WHYTES GULLY NEW LANDFILL CELL

Response to Submissions/Preferred Project Report

Submitted to:
NSW Department of Planning and Infrastructure

Report Number. 117625003

Figure 4: Revised Staging Plan

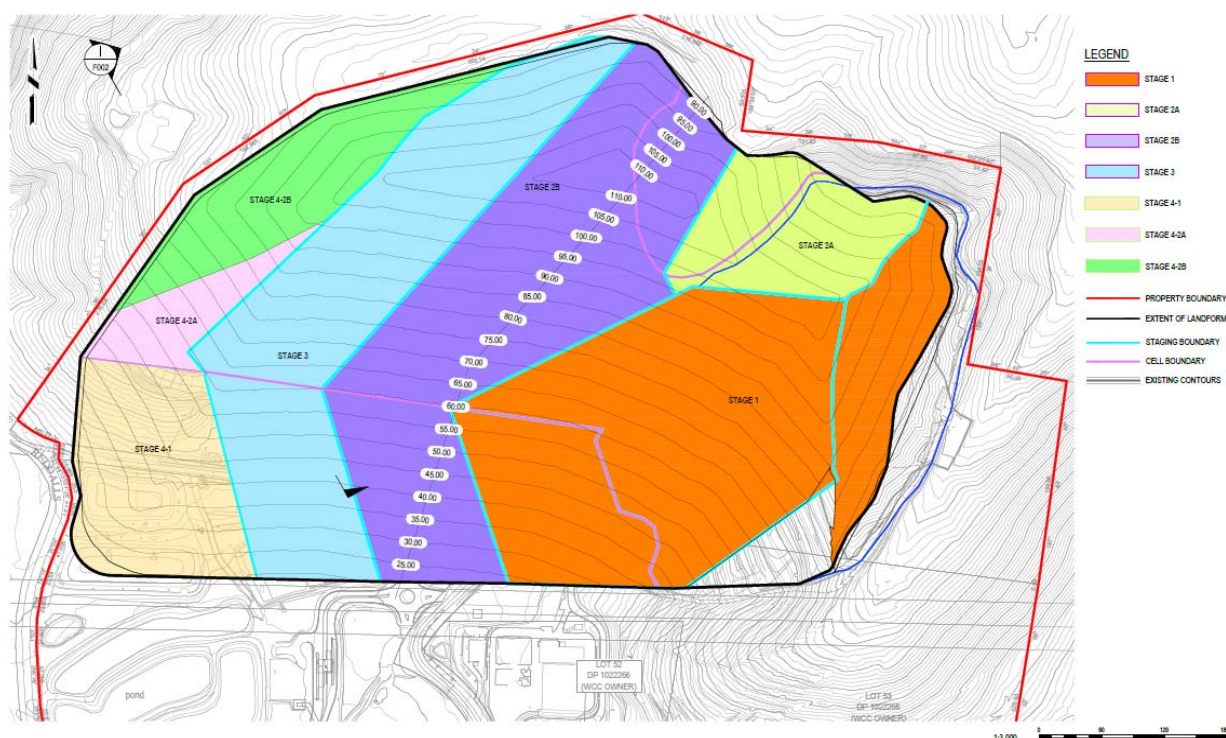
- 1) *The Department needs to be satisfied that the project would achieve an acceptable acoustic environment for local residents.*
- 2) *As discussed at our on-site meeting on 21/9/2012, the Department suggests that you consult with the EPA and consider reducing the footprint of landfilled waste in Stage 4 to increase the buffer distance between N1 and reduce noise levels to comply with the INP amenity criteria. In this regard, a preferred project report which addresses this issue should be submitted to the Department as part of your response to submissions report.*

- 3) *The cumulative (ie construction and operation) predicted noise levels at receivers N1 and N2 are significantly greater than the Project Specific Noise Level (PSNL) – up to 54 dBA at N1 and 45 dBA at N2. The proponent has not provided any description of feasible and reasonable mitigation measures to reduce the predicted levels. The EPA advises that it does not normally Licence to levels significantly greater than the PSNLs.-*
- 4) *The EPA has not included receivers N1 and N2 in the noise limits table in the attached recommended licence conditions, on the assumption that Planning will advise the proponent that the negotiated agreements process in Chapter 8 of the INP is available to them, and that Planning will require the proponent to provide evidence of negotiated agreements being in place with N1 and N2 before any Project Approval can be issued.*

In response to comments 1, 2 and 3, to further reduce the potential cumulative effects of the construction and operational activities at Receiver N1, the final Stage (4-2) of the Project has been broken into two parts (Stage 4-2A and Stage 4-2B) (refer Figure 1). Stage 4-2B would be the final stage of the Project to be constructed. The division of the stages as shown in Figure 1 is such that all activity up to and including Stage 4-2A occurs behind the existing north-east ridgeline, and at a greater distance from Receiver N1 than for Stage 4-2B (refer Figures 2). It is proposed that approval of Stage 4-2B would be conditional on further noise modelling and assessment of mitigation measures to be conducted prior to construction. This has been reflected in the revised draft Statement of Commitments in Section 5.0 of the Report. Further details of the revised staging including proposed volumes and timelines are provided in Section 4.0 of the Report.

The breaking of Stage 4-2 into two parts allows a greater level of detail in modelling the level and duration of noise exposure to Receiver N1. The reduced duration of exposure is discussed in Section 4.0, and shows that for construction and operation activity nearest to Receiver N1 (in Stage 4-2B) is approximately six years, which is less than the nine years presented in the EA for the whole of Stage 4-2.
